February 4, 2016

G-3837

Subject: Response to November 18, 2015, Geotechnical Third Party Review Letter,
Proposed Residence, 5637 East Mercer Way, Mercer Island, Washington.

Reference: Geotechnical Third Party Review, 5637 E. Mercer Way, Mercer Island,
Washington (Perrone Consulting Project #15124). Perrone Consulting, Inc., P.S.,
November 18, 2015.

P1.0  
 SHORING/PIN PILE DETAILS

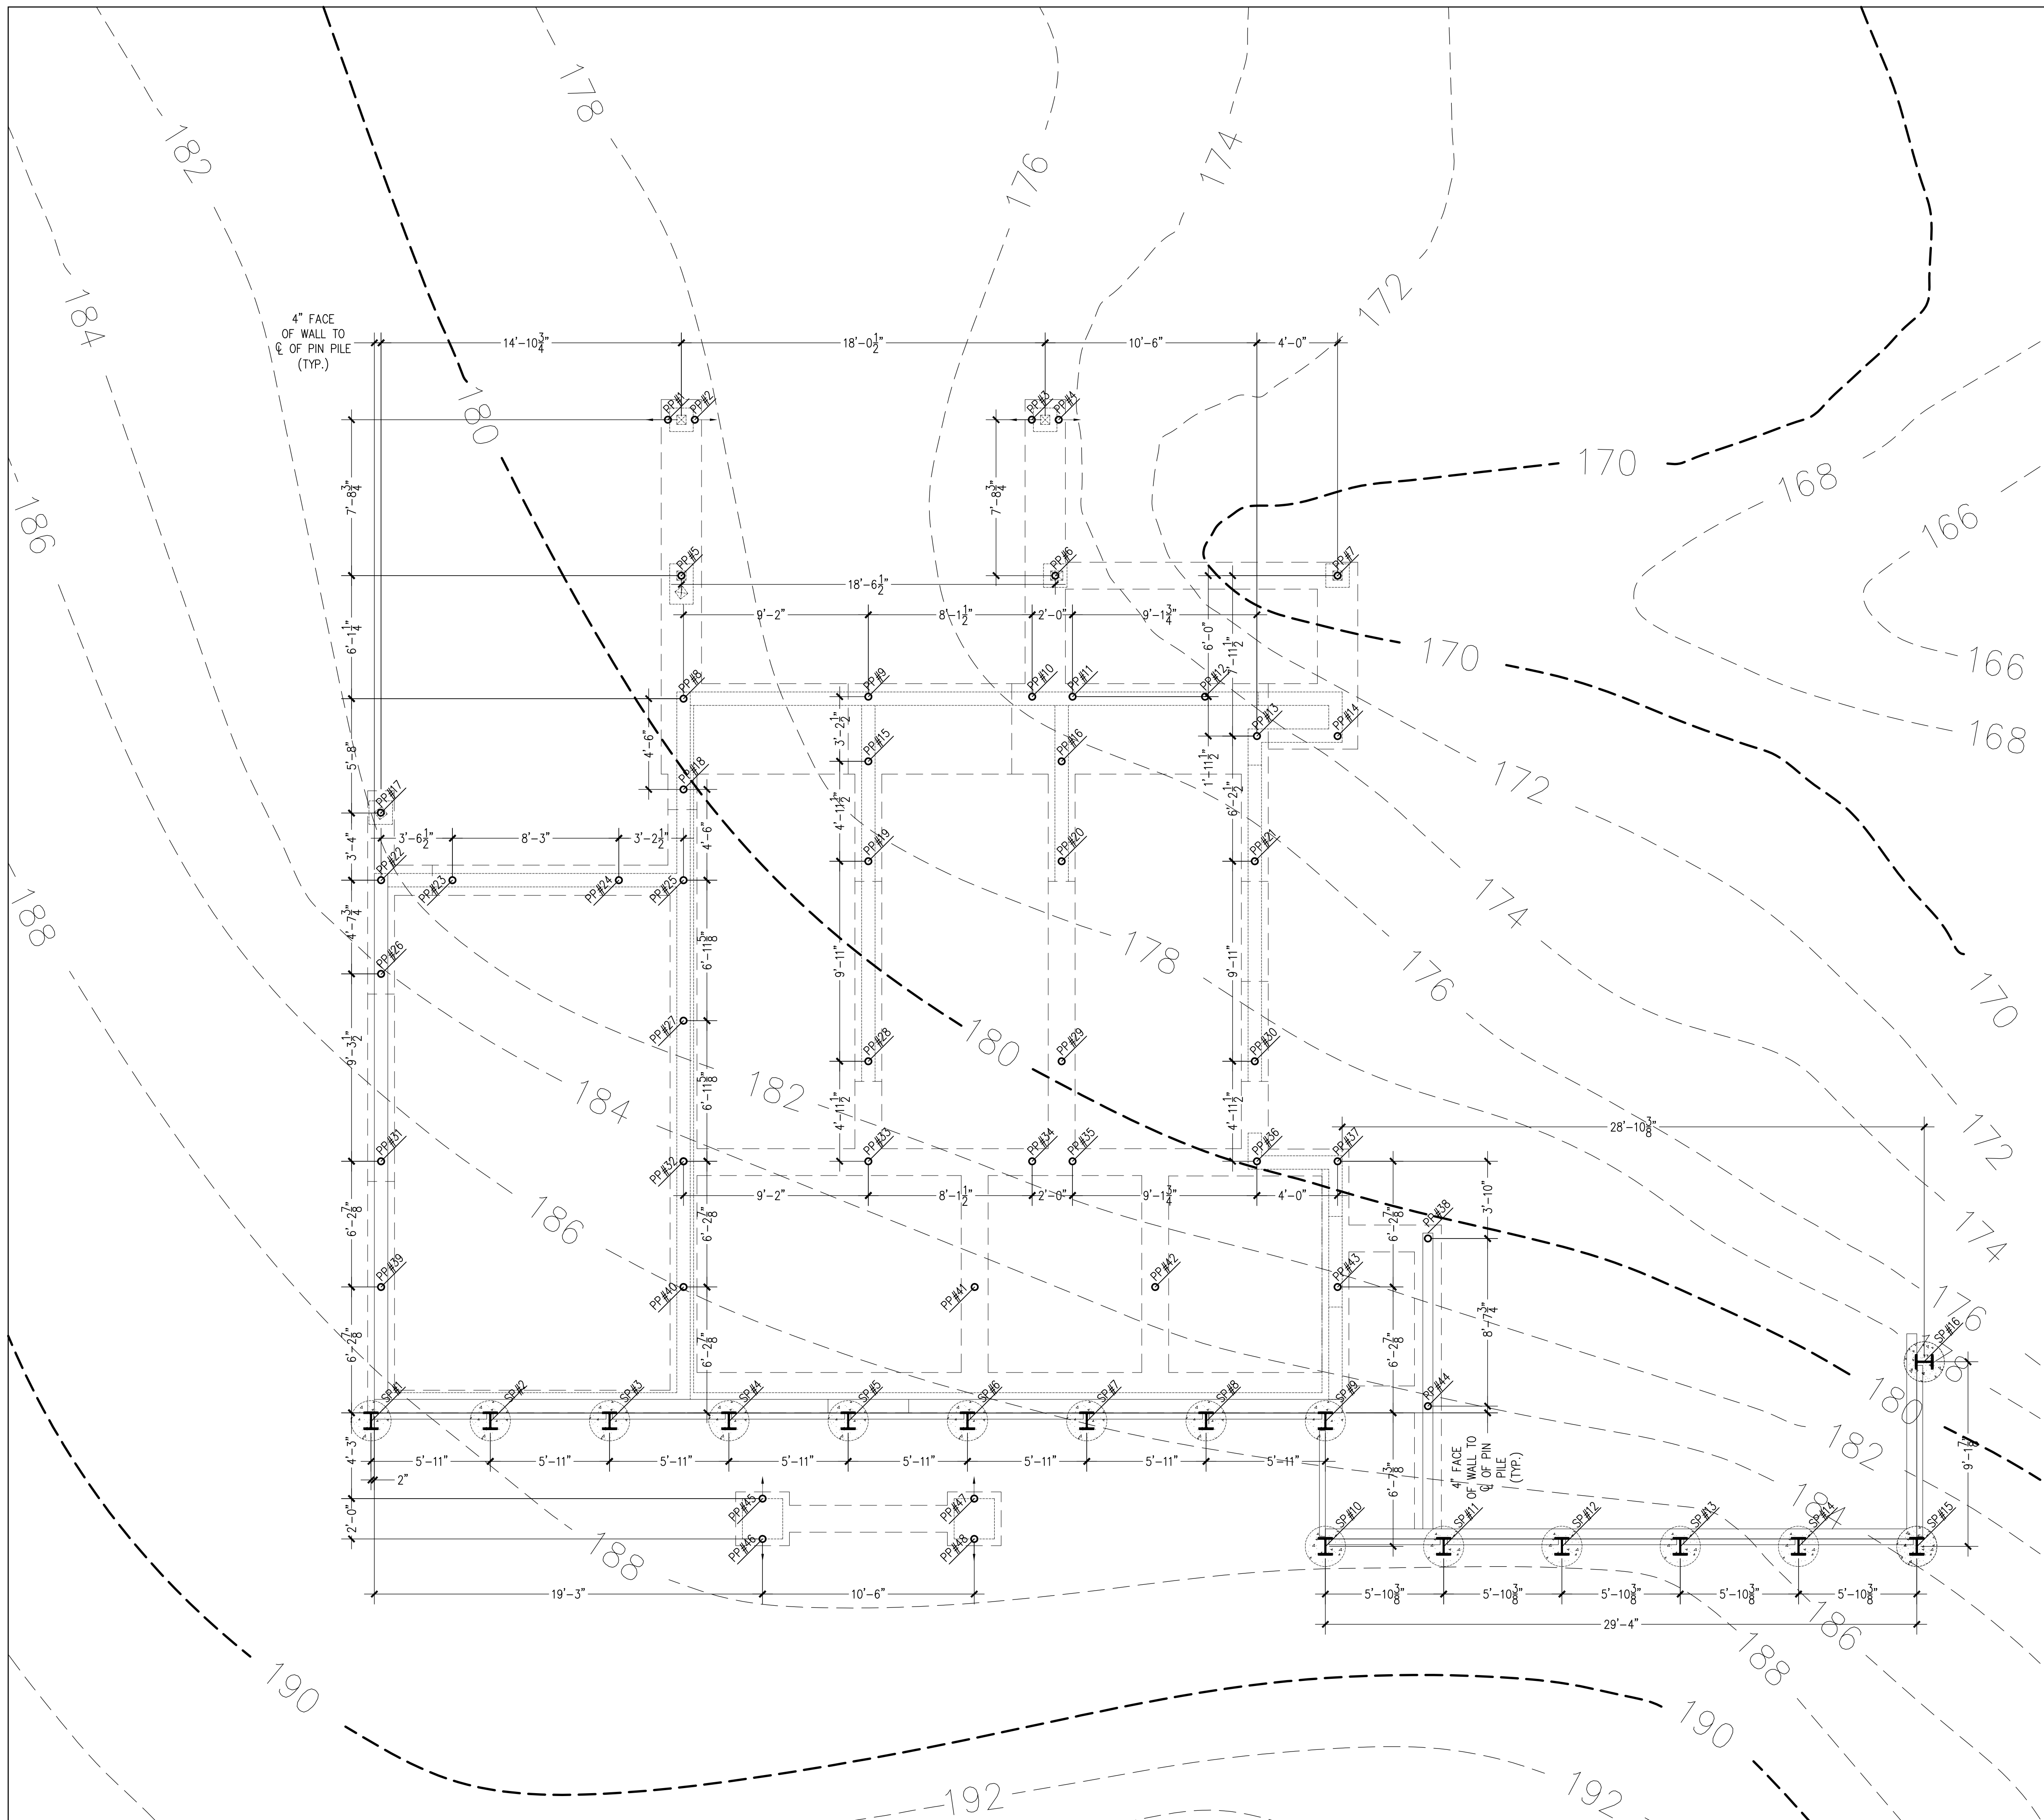
In our opinion, the potential for liquefaction or settlement of the loose sandy soils to exert significant down-drag forces on the steel pipe piles proposed for the project is relatively low. We have analyzed the potential down-drag force associated with settlement of these soils due to friction against the piles. For the case of an 18-foot thickness of saturated, loose, sandy soils (the maximum thickness scenario near boring B-2), full mobilization of potential down-drag forces is calculated to result in a down-drag load of approximately 2.0 tons per 4"-diameter pile and approximately 3.0 tons for per 6"-diameter pile.

Based on above analysis, it is our opinion that 4"-diameter Schedule 40 steel pipe piles can be considered to have an allowable net axial bearing capacity of 8 tons each (10 tons minus the 2.0 tons for potential down-drag) when successfully driven to the applicable refusal criteria described in our geotechnical report dated March 13, 2015. Net capacity for 6"-diameter Schedule 40 steel piles can be assigned as 12 tons each (15 tons minus the 3.0 tons for potential down-drag).
